TAMIL NADU HOUSING BOARD
SPECIAL PROJECT DIVISION-I

Sub: TNHB -Special Project Division I - Proposed Construction of 510 No's of Multi Storied Building LIG flats (Stilt + 15 Floors) in S.No's.738part, 739part, 742 and 743part at MKB Nagar, Perambur Village, Perambur Taluk, Chennai -(150 LIG Block-I & 3 no's of 120 LIG Block 2,3 &4))under Self Finance scheme - Planning Permission-Remittance of DC and other charges paid receipt Requested -- Regarding.

Letter No.C3(N)/2530/2016,dated : ~~12~~ 12.2016

Sub: CMDA – Area Plans Unit – MSB (North) Division – Planning permission for the proposed construction of Multi storied building consisting of Block 1, Block 2, Block 3 & Block 4 of Stilt Floor + 15 Floors residential building with 510 dwelling units in S.No.738pt, 739pt, 742pt&743pt Perambur Village, Permbur-Purasawalkkam Taluk, Chennai— Remittance of DC and Other Charges – ~~DC~~ Advise sent – Reg.

SHEET NO. 01/07

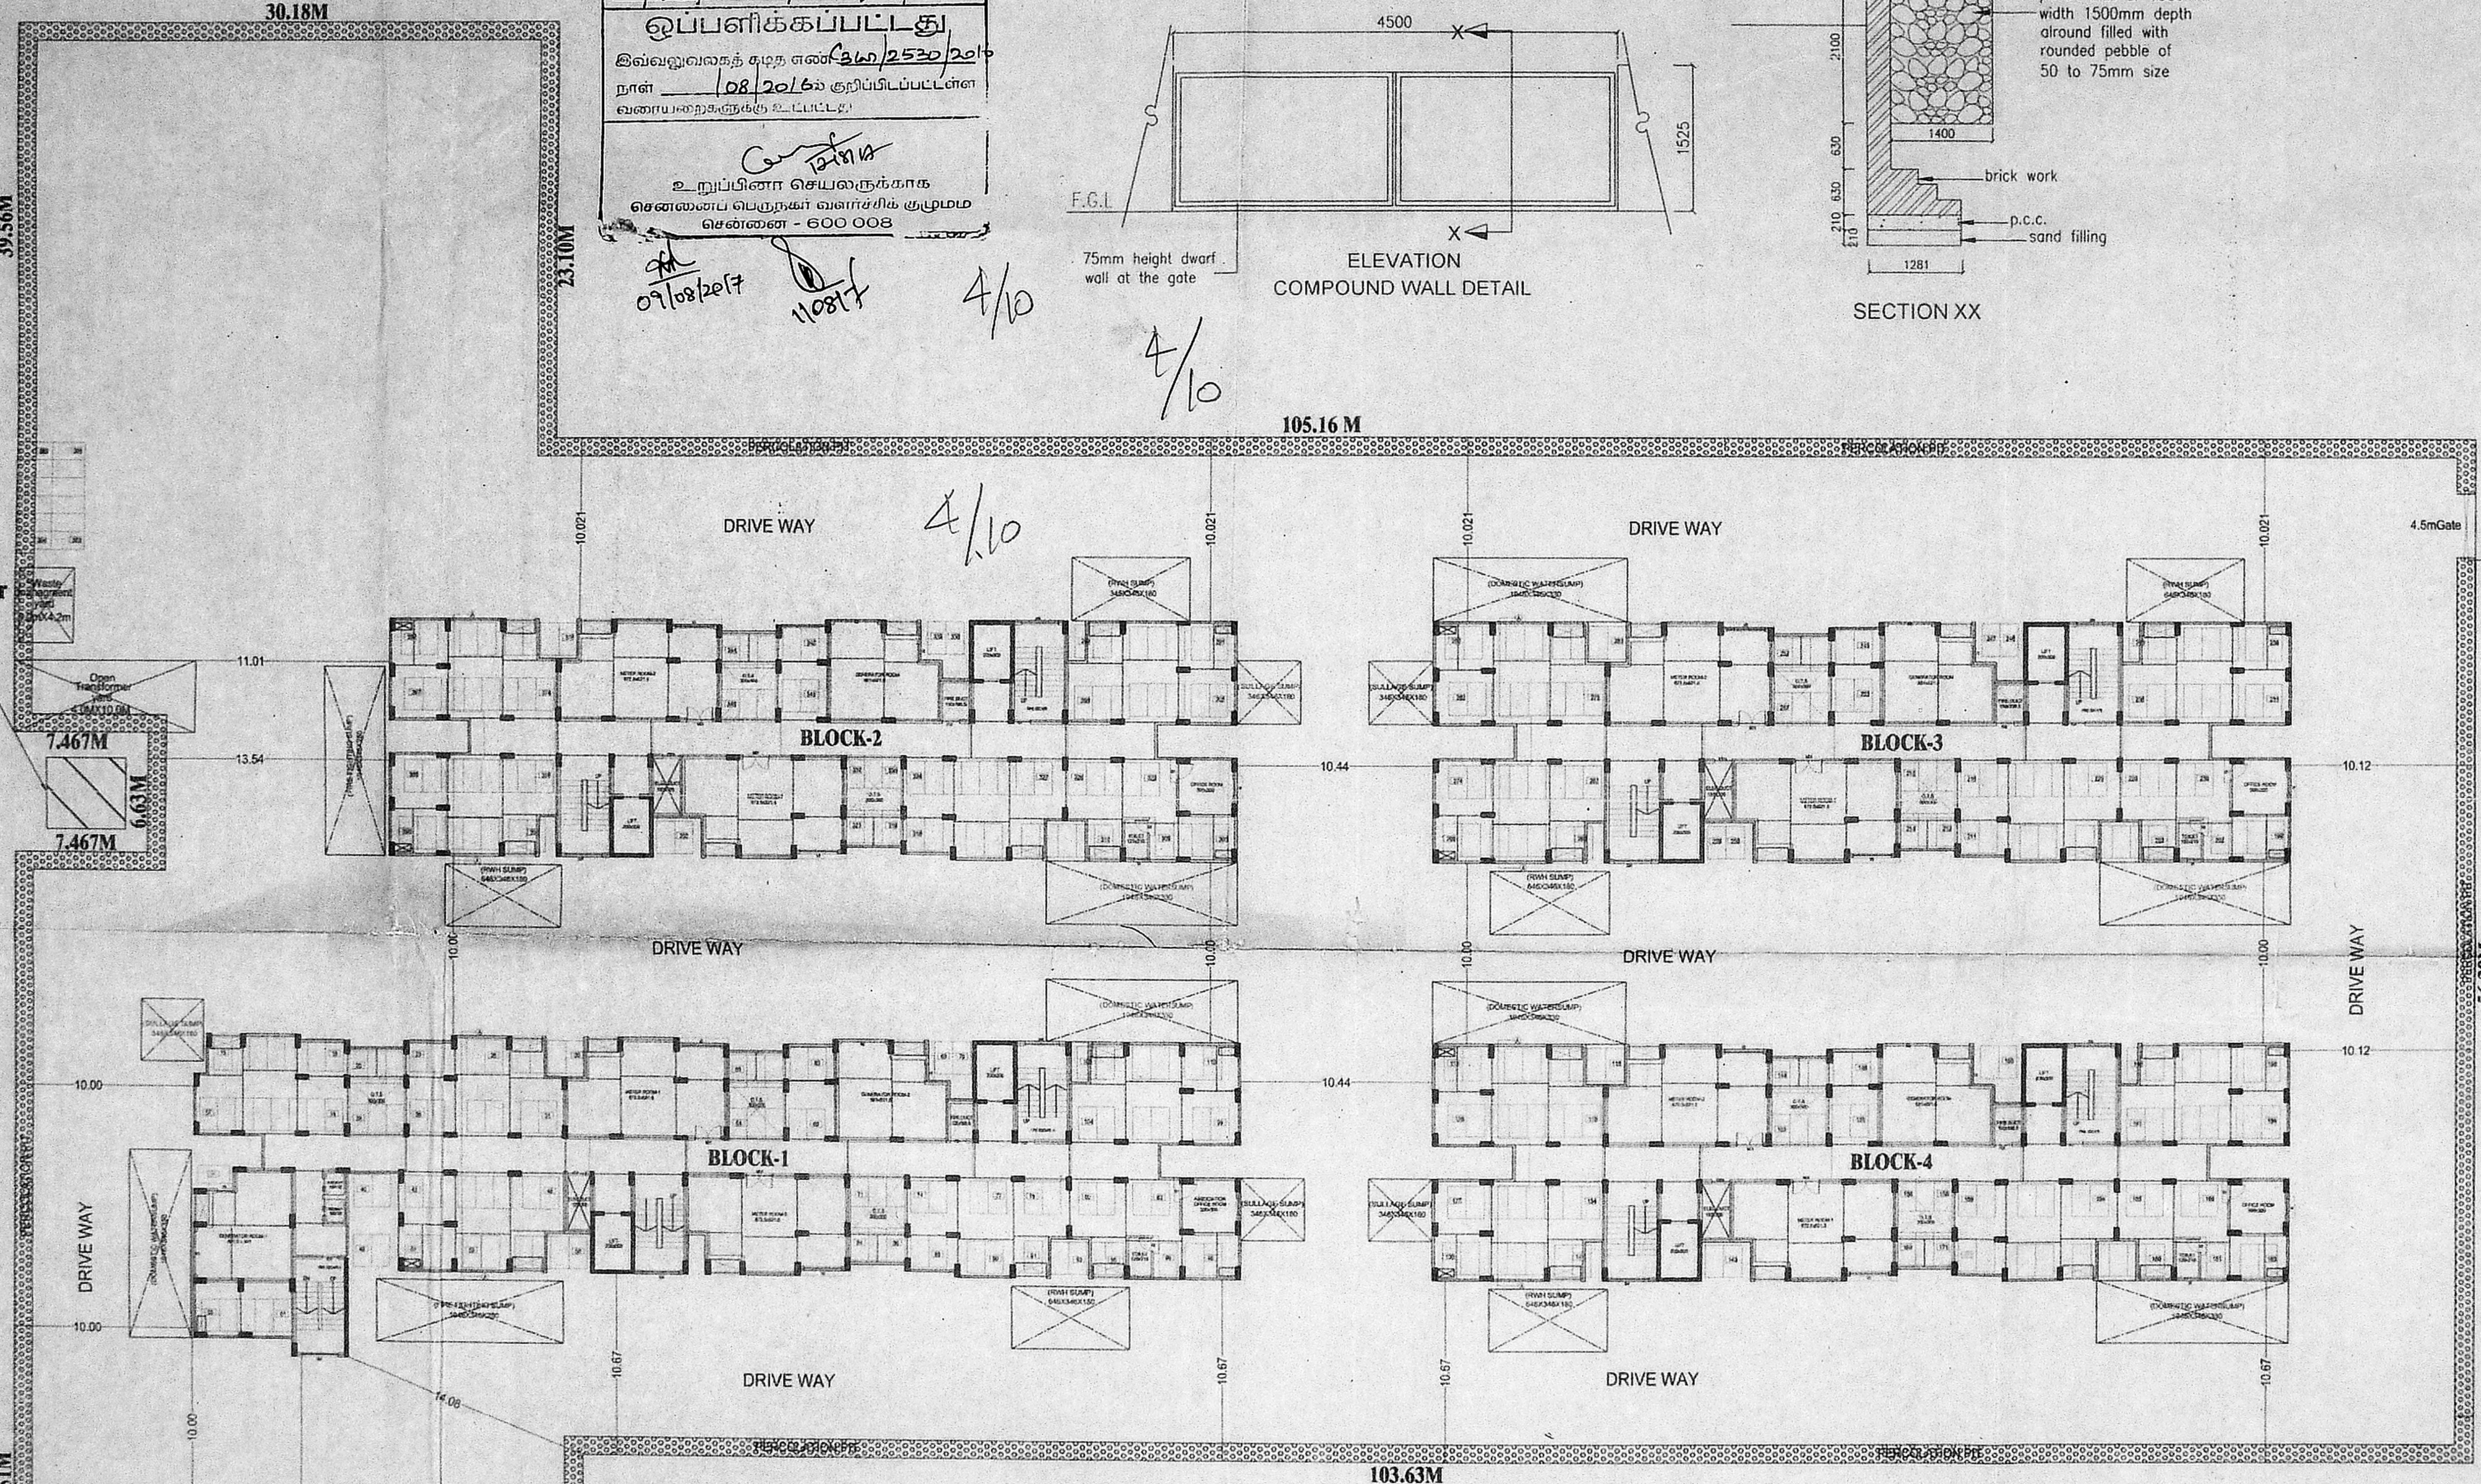
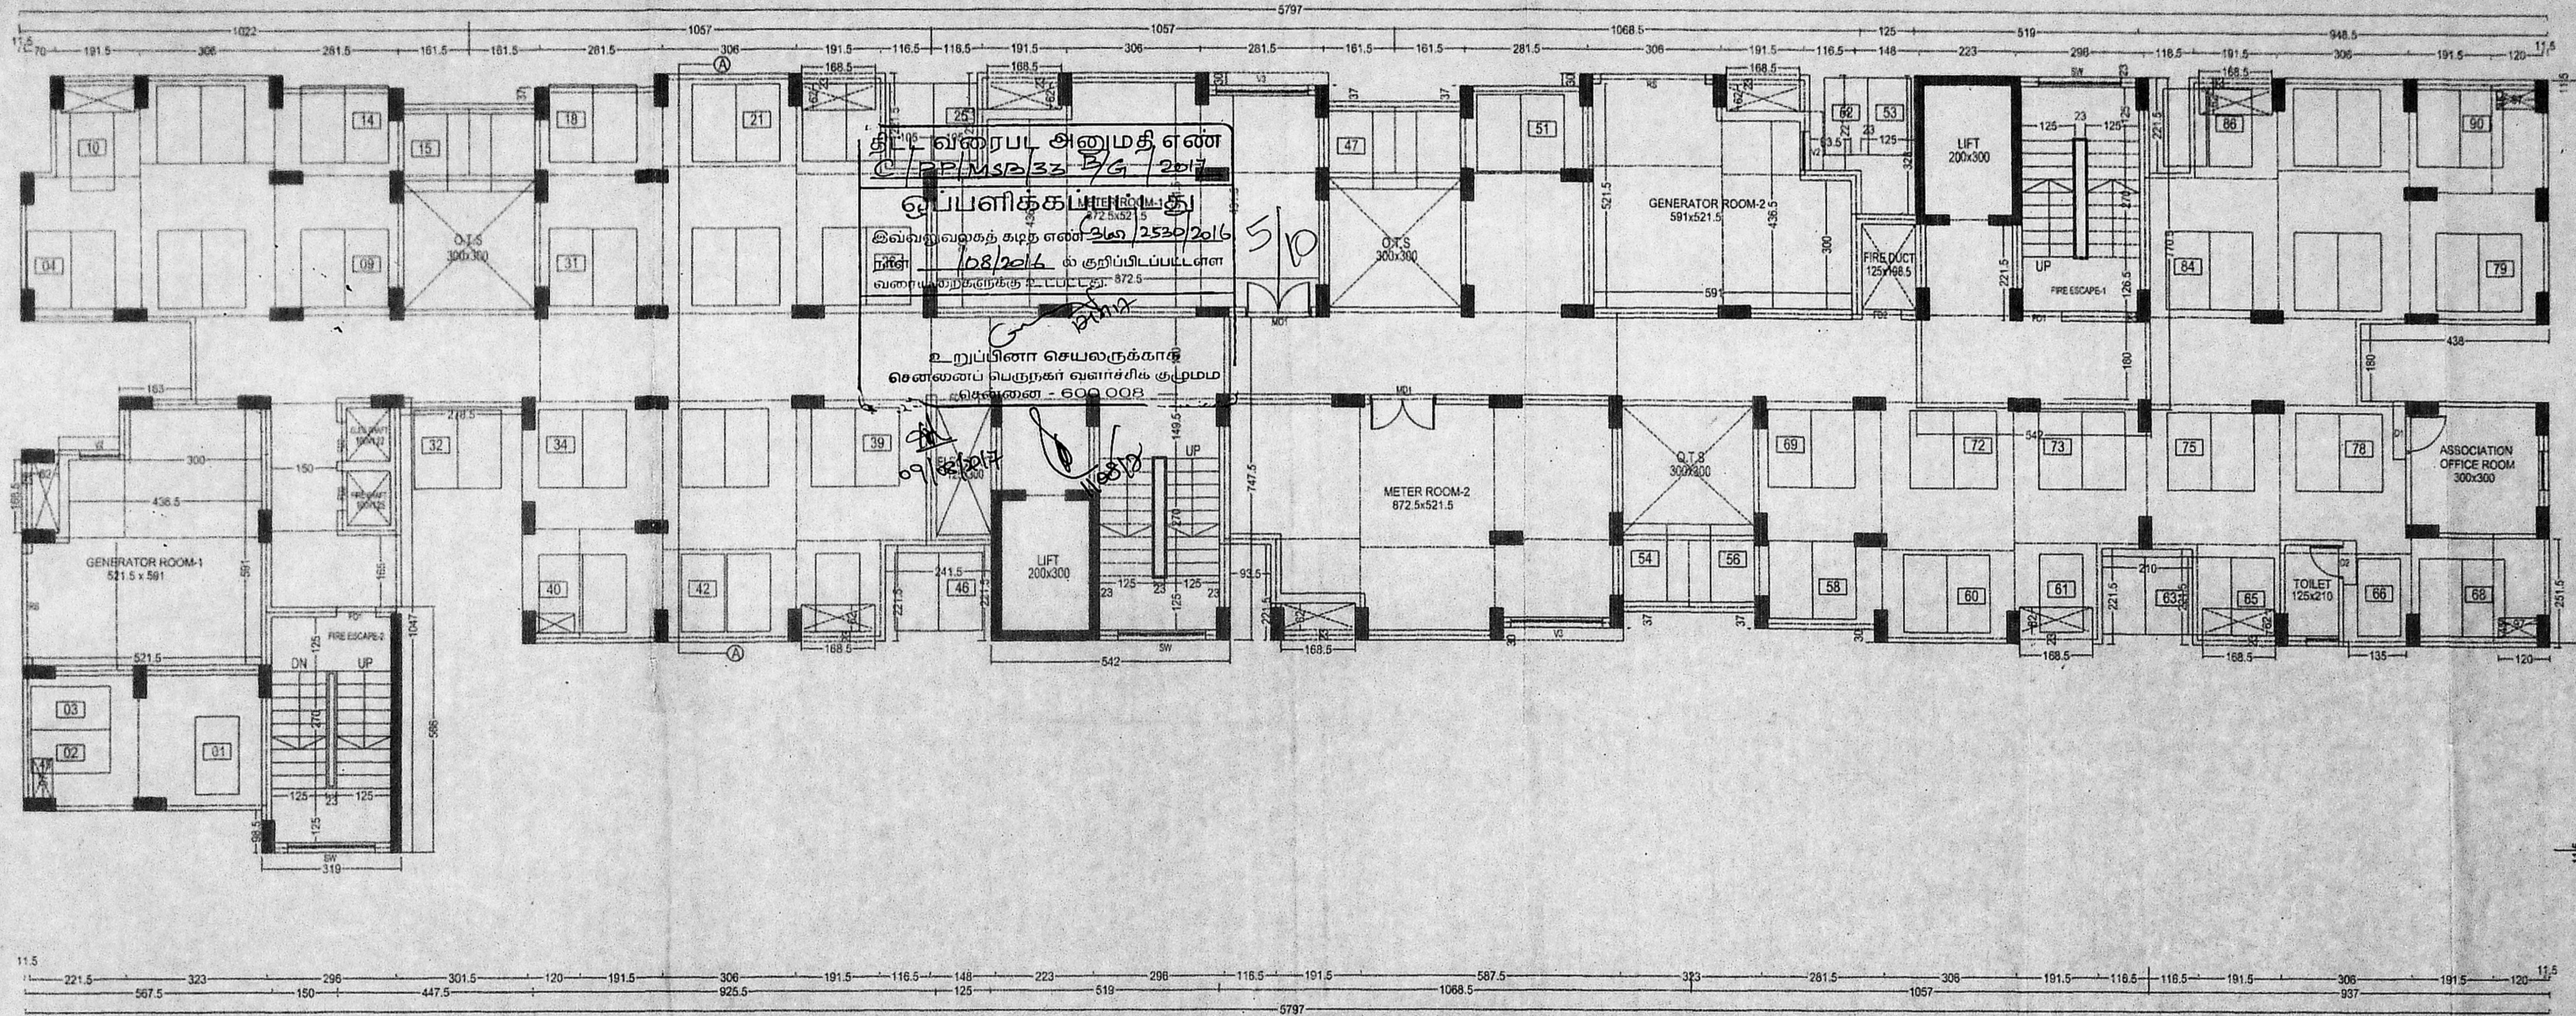
- 7) Handrail to be shown for balconies and service verandah.
- 8) Stilt height to be shown from the bottom of the beam
- 9) STP to be shown in the site plan.

- 14) OHT for Sullage water, RWH and Firefighting to be shown.
- 15) Sump and OHT to be provided as per the required capacity of DF&RS NOC conditions.
- 16) Future development shown in the site plan to be removed.

- 17) Site plan showing 10.0^m setback free from any hinderance as specified in the DF&RS NOC to be furnished.
- 18) Head room to be mentioned properly in the terrace floor plan.

PLAN RAIN WATER COLLECTION SUMP

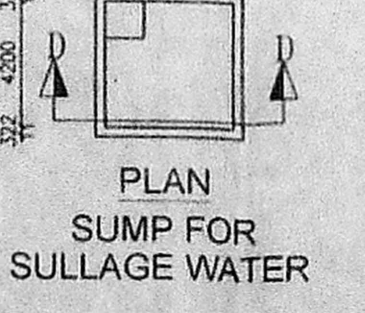
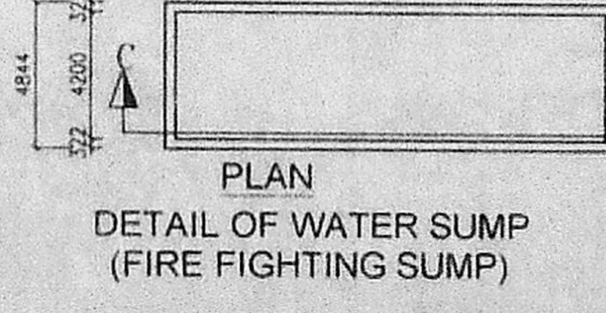
- 4) Undertaking for structural stability and supervision in prescribed format (PP1 & PP2) to be furnished.
- 5) Sumps for RWH are to be provided.
- 6) Lightening arrestor to be shown properly and the total height of the building to be shown from the lightening arrestor.

STILT FLOOR PLAN PART / GROUND FLOOR PART - BLOCK-1

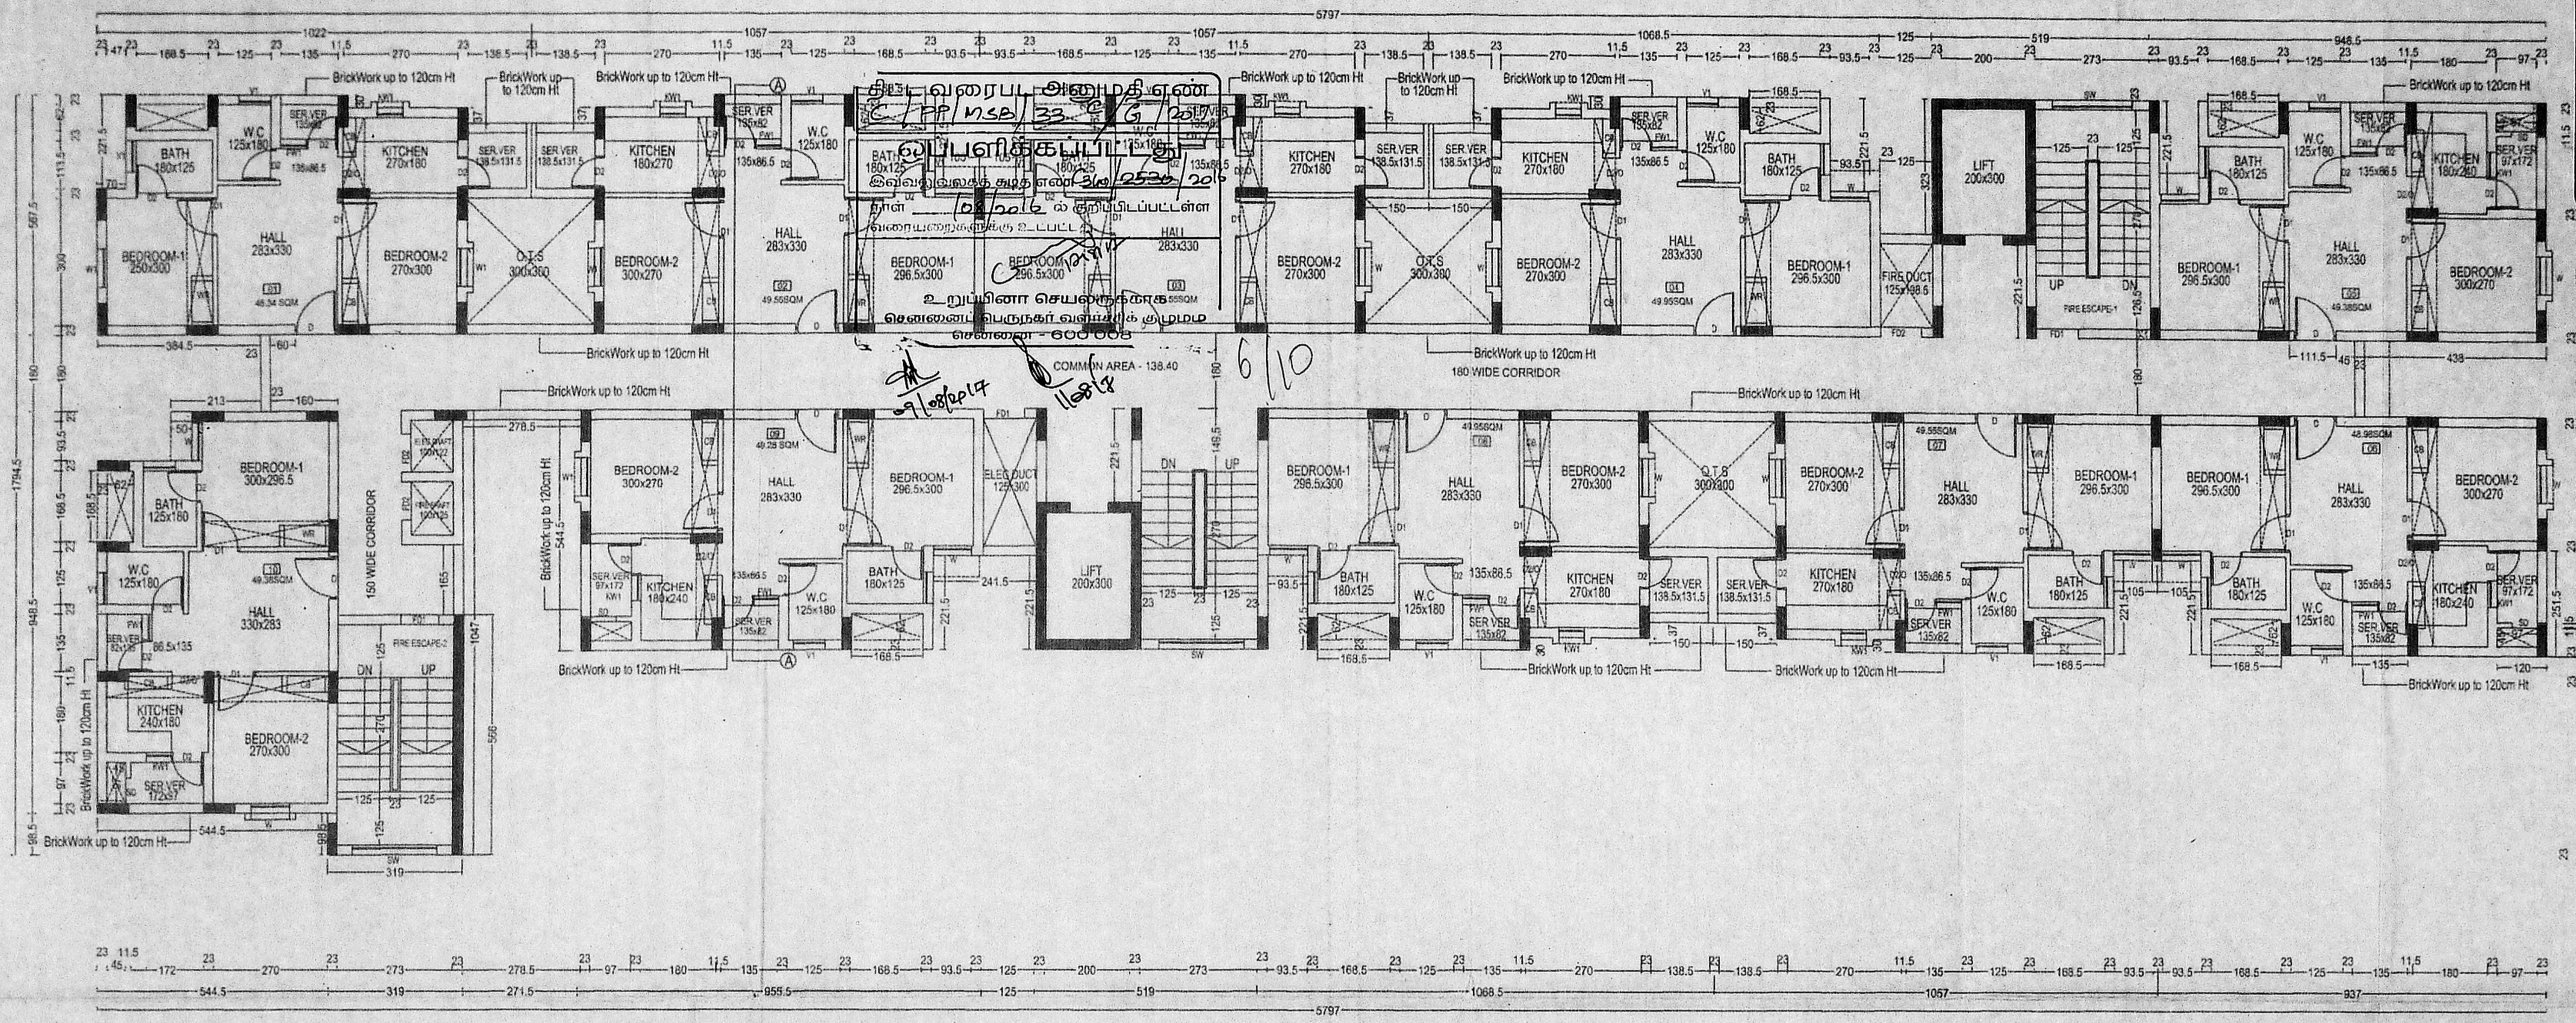
- 1) Provision of Association room in stilt floor is not permissible; hence the stilt floor to be renamed as Stilt floor (part)/Ground floor (part).
- 2) Office room in the Stilt floor in Typical blocks (Block 2, 3, 4) to be renamed as Association office room.
- 3) Pump room is not allowed in the setback spaces.
